# COLORADO GEOLOGICAL SURVEY

December 19, 2016

**Subject:** **North Bay at Lake Woodmoor – PUDSP-16-004**  
**El Paso County, CO; CGS Unique No. EP-17-0024**

The Colorado Geological Survey has reviewed the North Bay at Lake Woodmoor development referral. The applicant proposes to divide 7.23 acres to create 28 townhome lots at the north end of Woodmoor Lake near the intersection of Woodmoor Drive and Deer Creek Road in Monument, Colorado. As indicated in the letter of intent, the site is located between two existing developments: “The Cove at Woodmoor” condominiums and the “Lake Woodmoor” residential neighborhood.

**FLOODPLAIN AND  
FLOODWAY  
EXHIBIT**

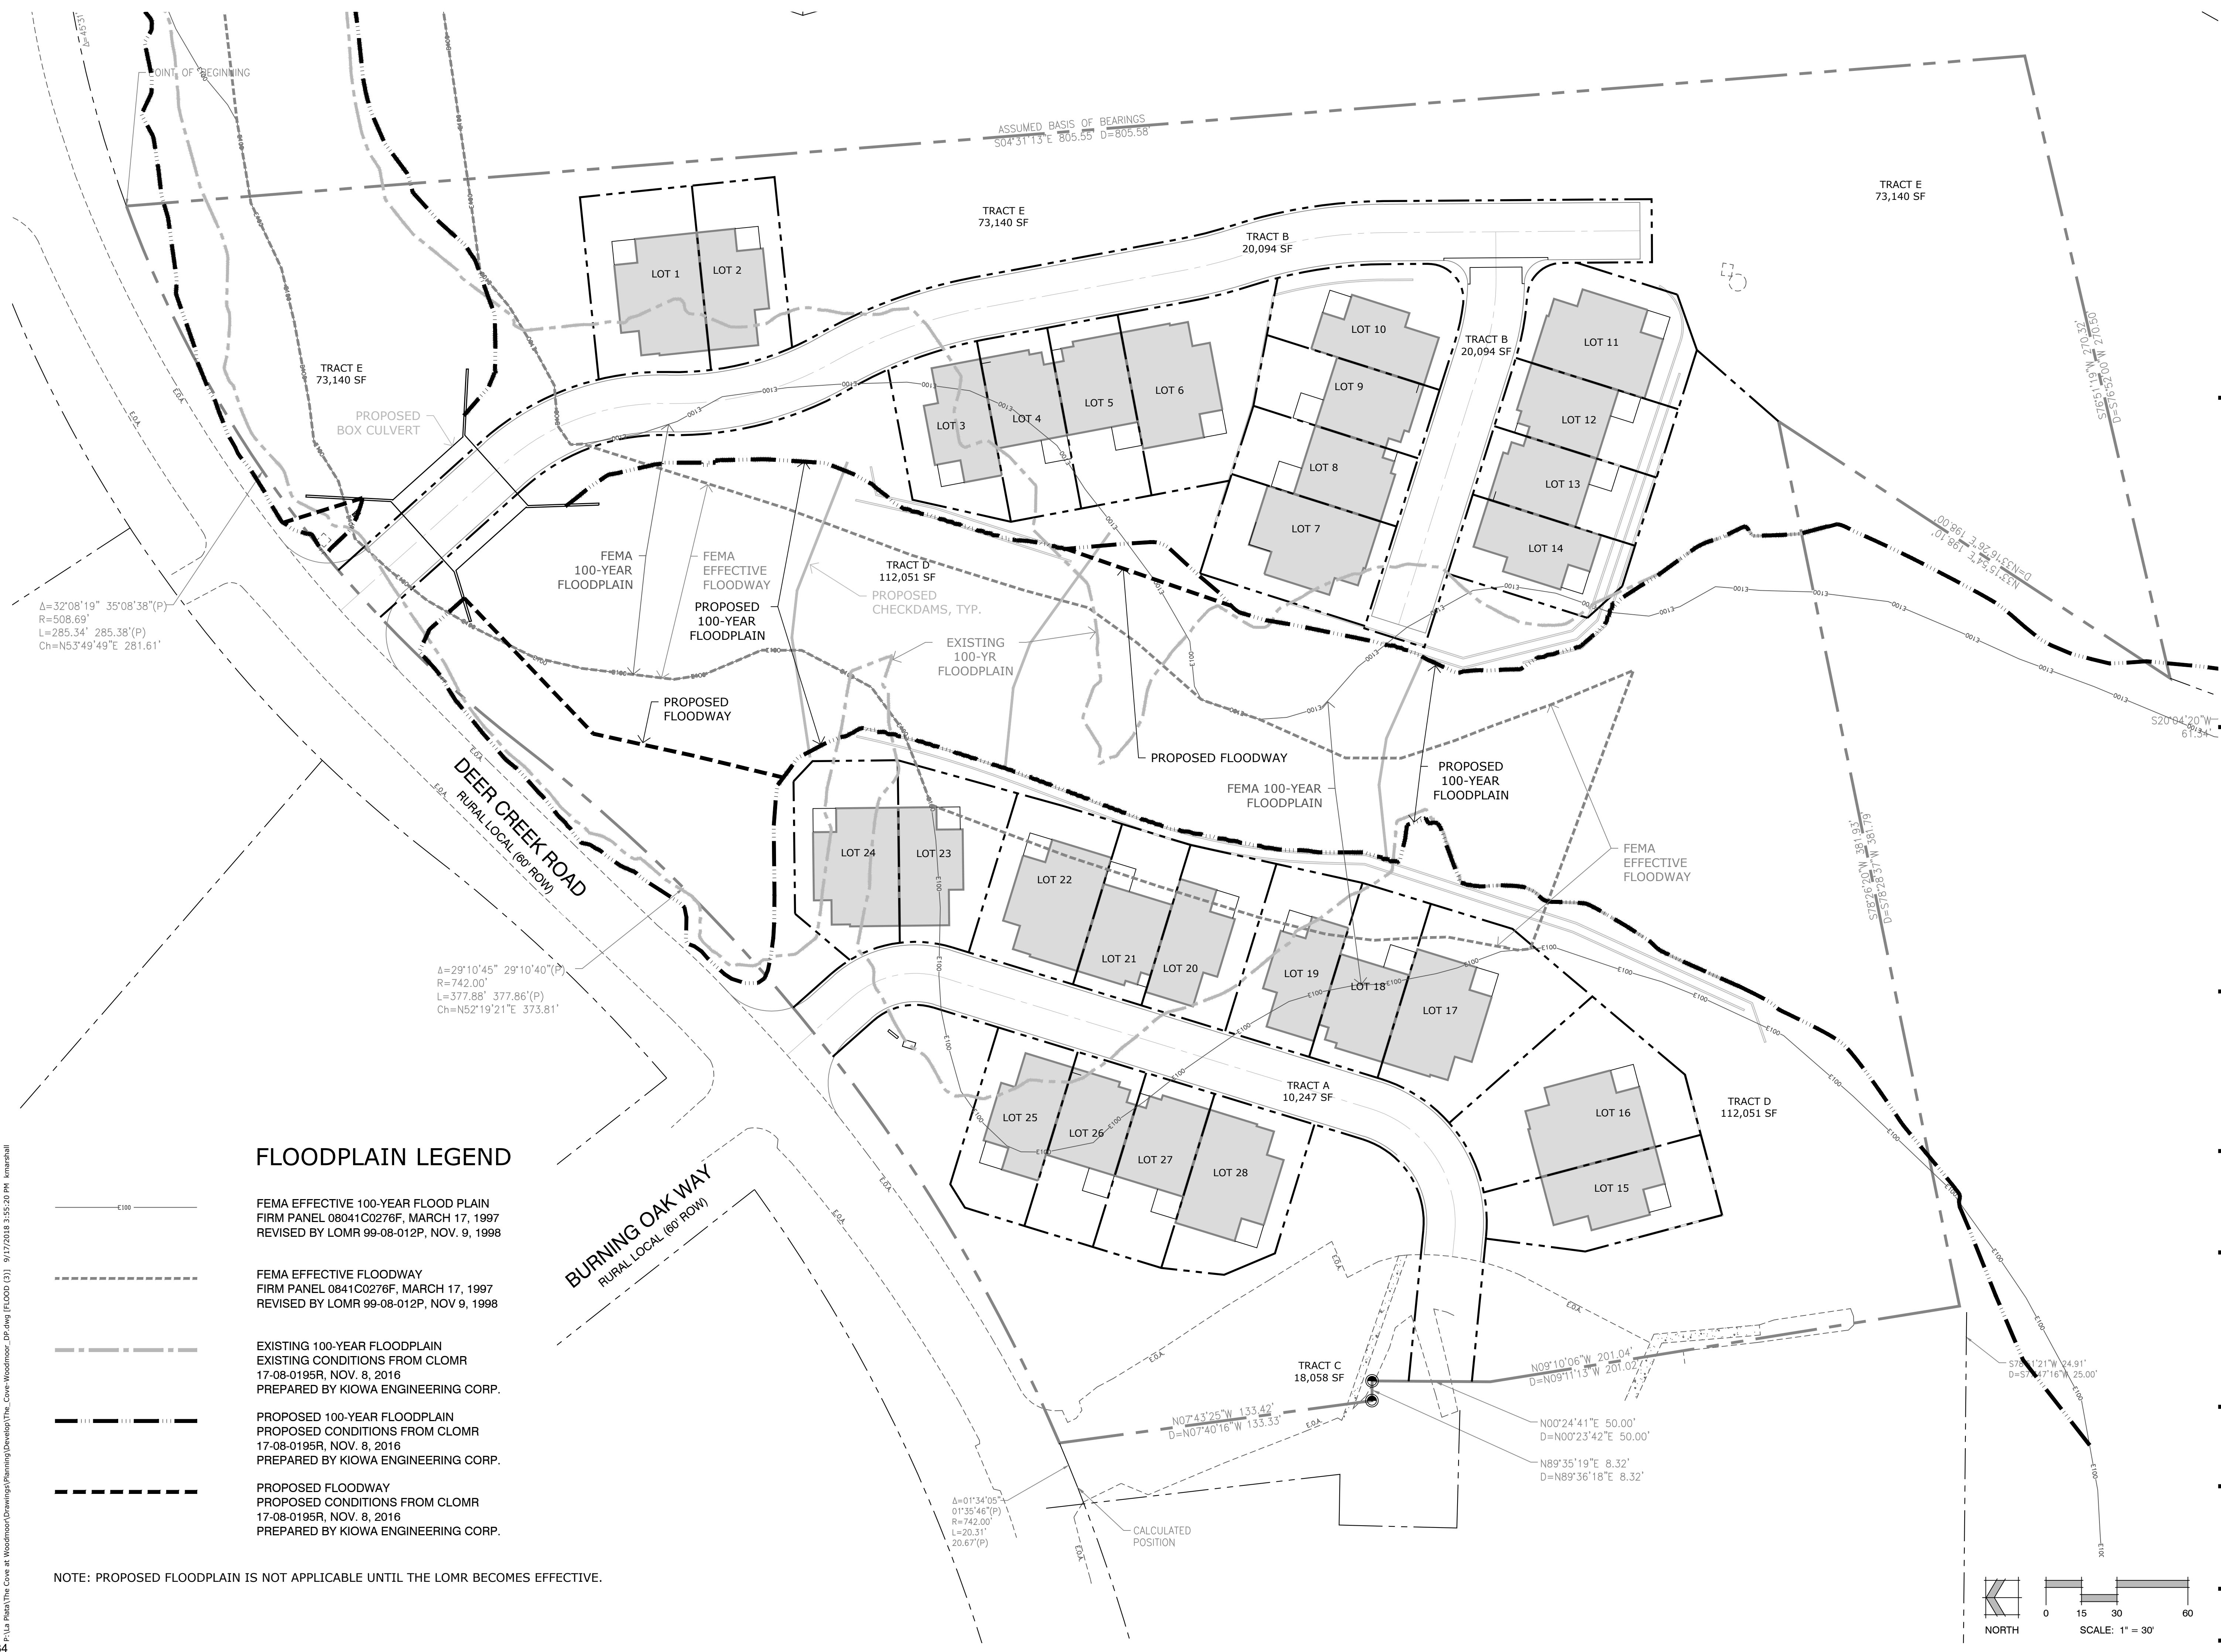
**Flooding and bedrock erosion.** As noted by CTL Thompson, a mapped FEMA 100-year floodplain crosses through the site. The CTL Thompson report and the PUD Development Plan drawings indicate that the existing floodplain will be channelized to create an engineered floodway through the center of the property. Additionally, the PUD Development Plan drawings show retaining walls along several stretches of the proposed floodway. As noted by CTL Thompson (p. 9), soil and bedrock at the site are susceptible to wind and water erosion; in particular, as pointed out in the documentation for the Geologic Map of the Monument Quadrangle (Thorson and Madole, 2003), the Dawson Sandstone (TKda5) can be friable and easily eroded on weathered outcrops. If present and left unprotected during extreme flooding events, weathered bedrock exposed along the outside bend of the floodway could be subject to lateral erosion potentially undermining the proposed retaining walls and/or nearby parts of the developed area. CTL Thompson noted that they did not observe weathered lenses in their borings, but it is unclear what the conditions are along the edge of the proposed floodway. **The possible presence of erodible weathered bedrock along the edges of the proposed floodway should be evaluated; additional erosion control measures should be designed as necessary by a qualified professional and implemented to reduce potential erosion of weathered bedrock during flood events.**
